Re: Proposed development of 26 no. wind turbines and associated works.
at the Ballivor Bog Group, Co. Meath and Co. Westmeath.

Please be advised that the Board, in accordance with section 37(F)(1) of the Planning and Development Act 2000, as amended, hereby requires you to furnish the following further information in relation to the effects on the environment of the proposed development: .

Figure 13-2 (below) shows the topographical features and elevation gradients existent within the receiving landscape of the LVIA Study Area, the geography of these topographical landforms defines the distribution of theoretical visibility illustrated in Figure 13-1.

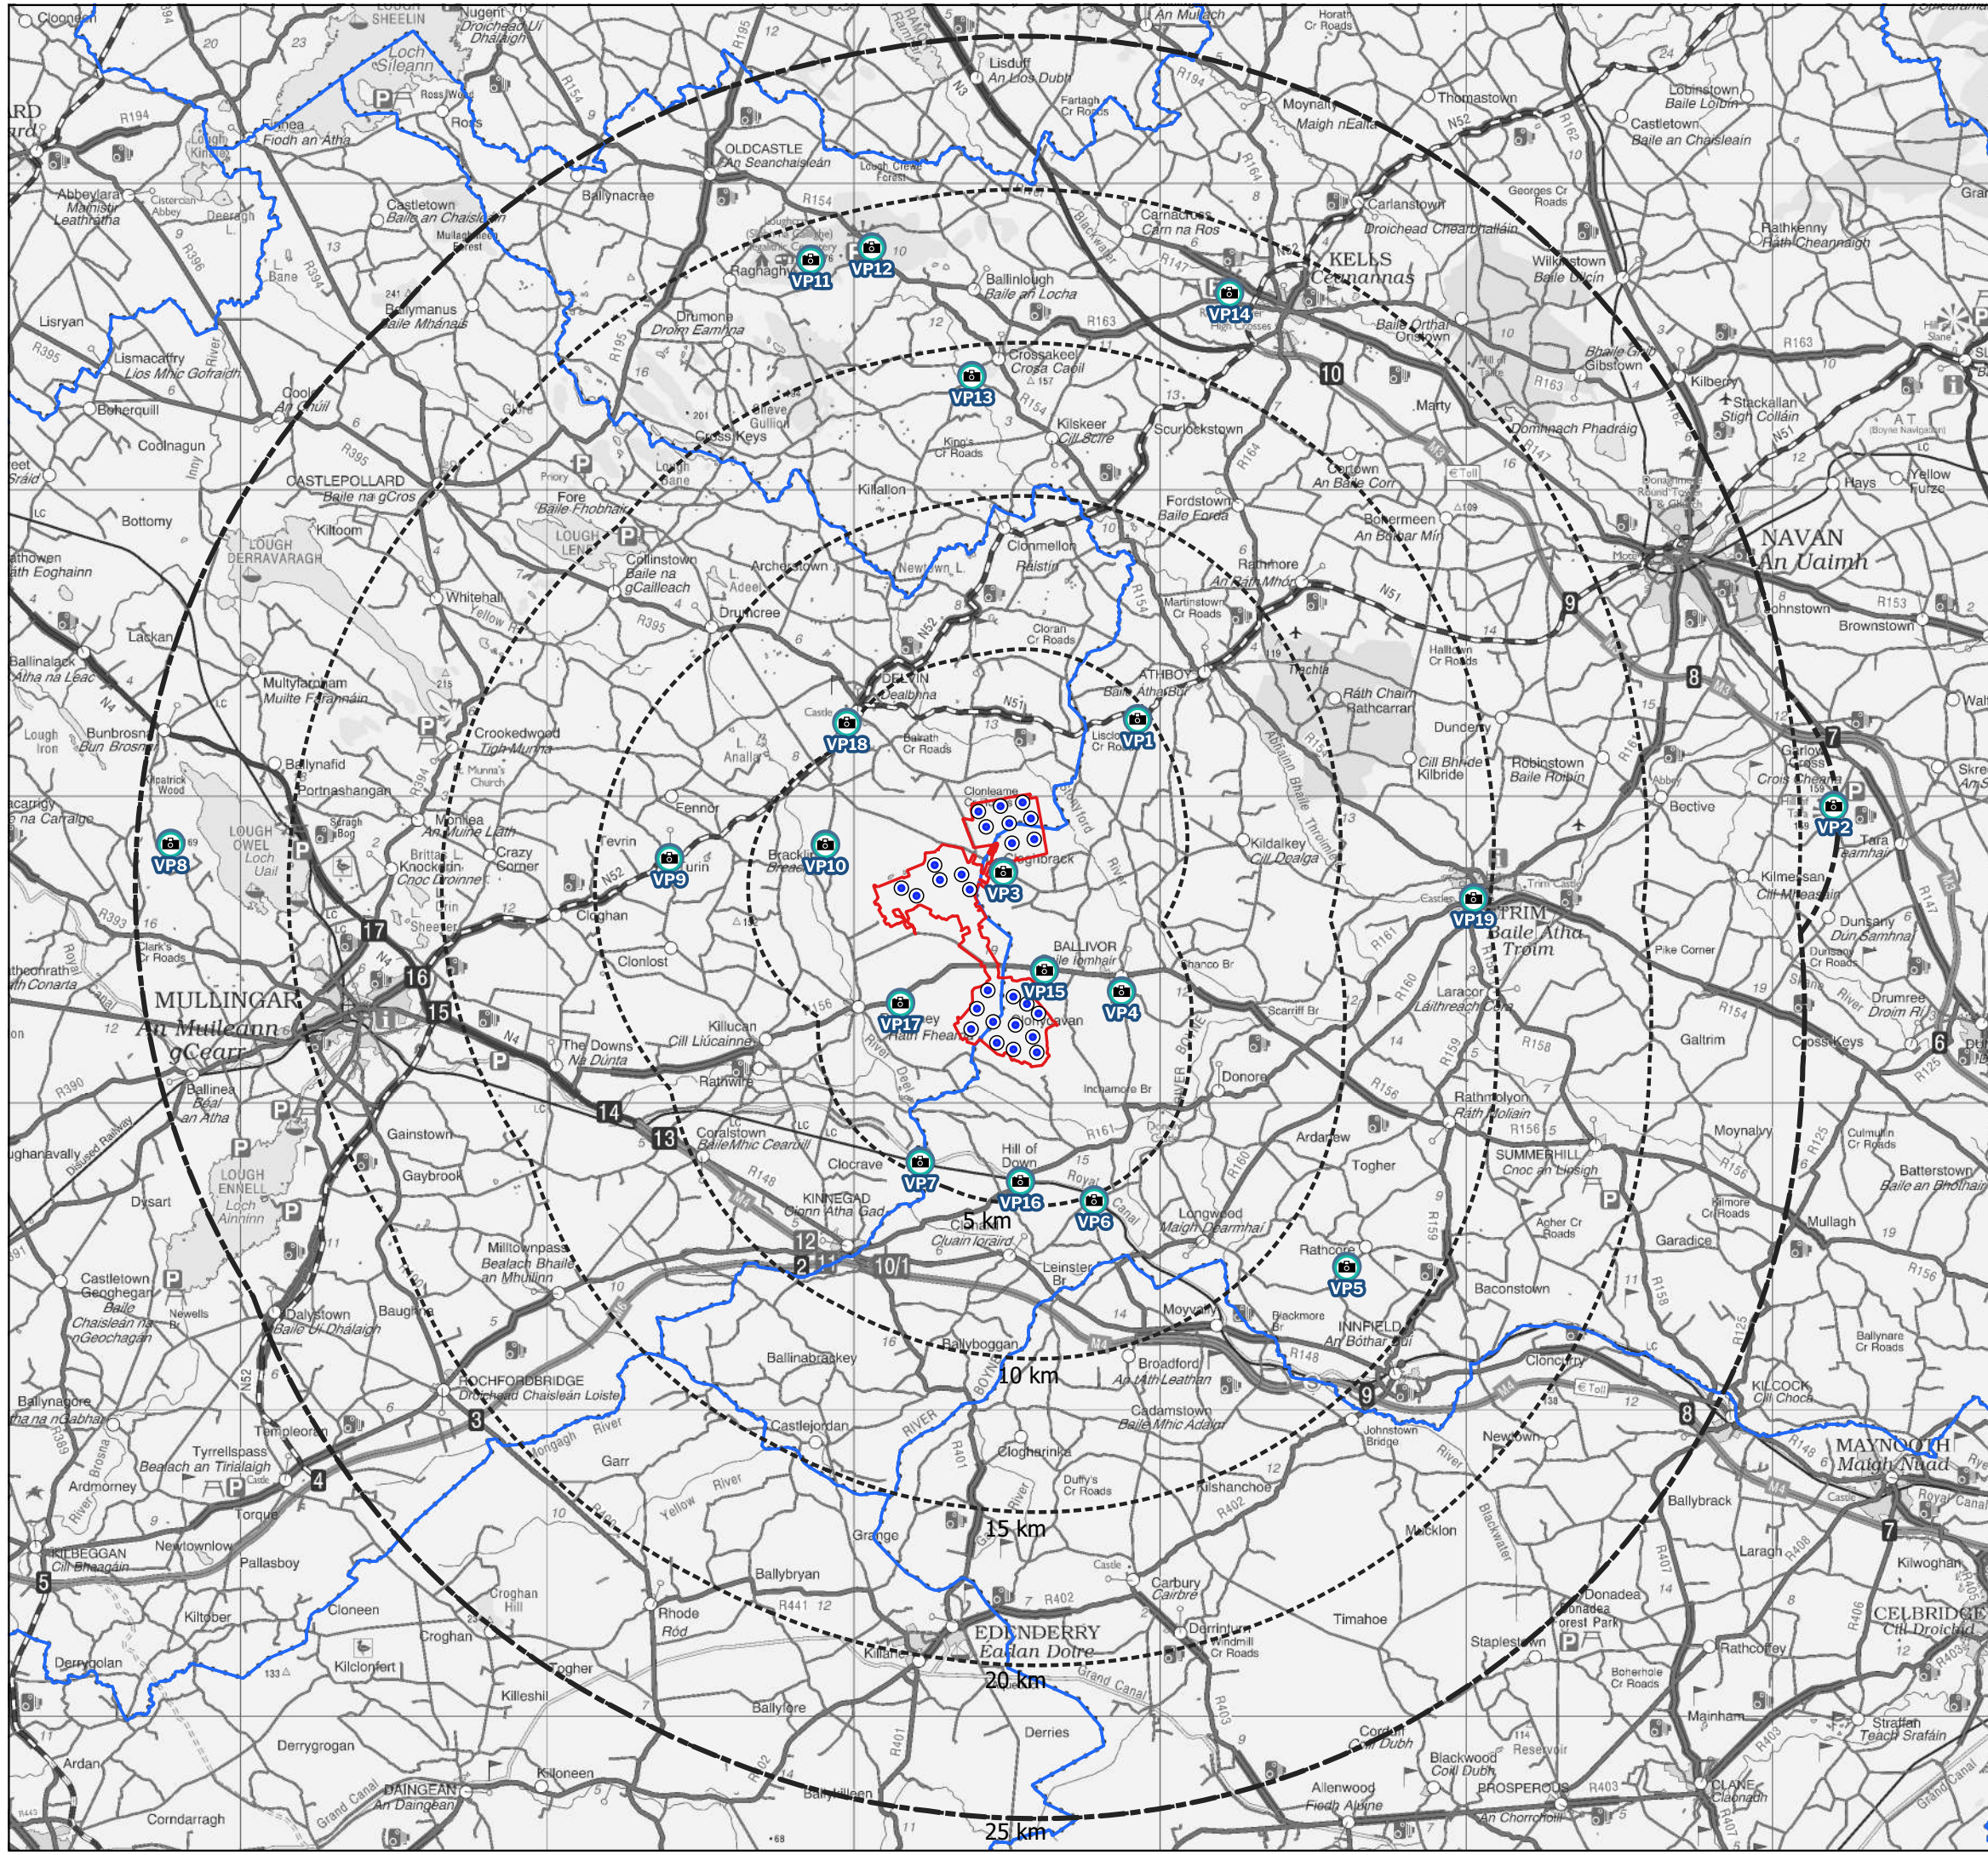
3. ZTV Mapping - The applicant is advised to note that the ZTV mapping colour banding error evident on the initial half blade ZTV map Fig 13-1 (digital and hard copy), a digital malfunction as referenced by you in the response to the observations, is also evident within the digital copy of further information on the standalone website - Response to Observations Received (ballivorwindfarmplanning.ie) at Fig 5 and Fig 13.1, though the colour banding is present on the hard copy documents submitted to the Board. It is acknowledged that the colour banding is evident (digital and hard copy) on several of the other mapping figures included within the EIAR including the LVIA baseline map Fig 13-5, and landscape character areas Fig 13-11.
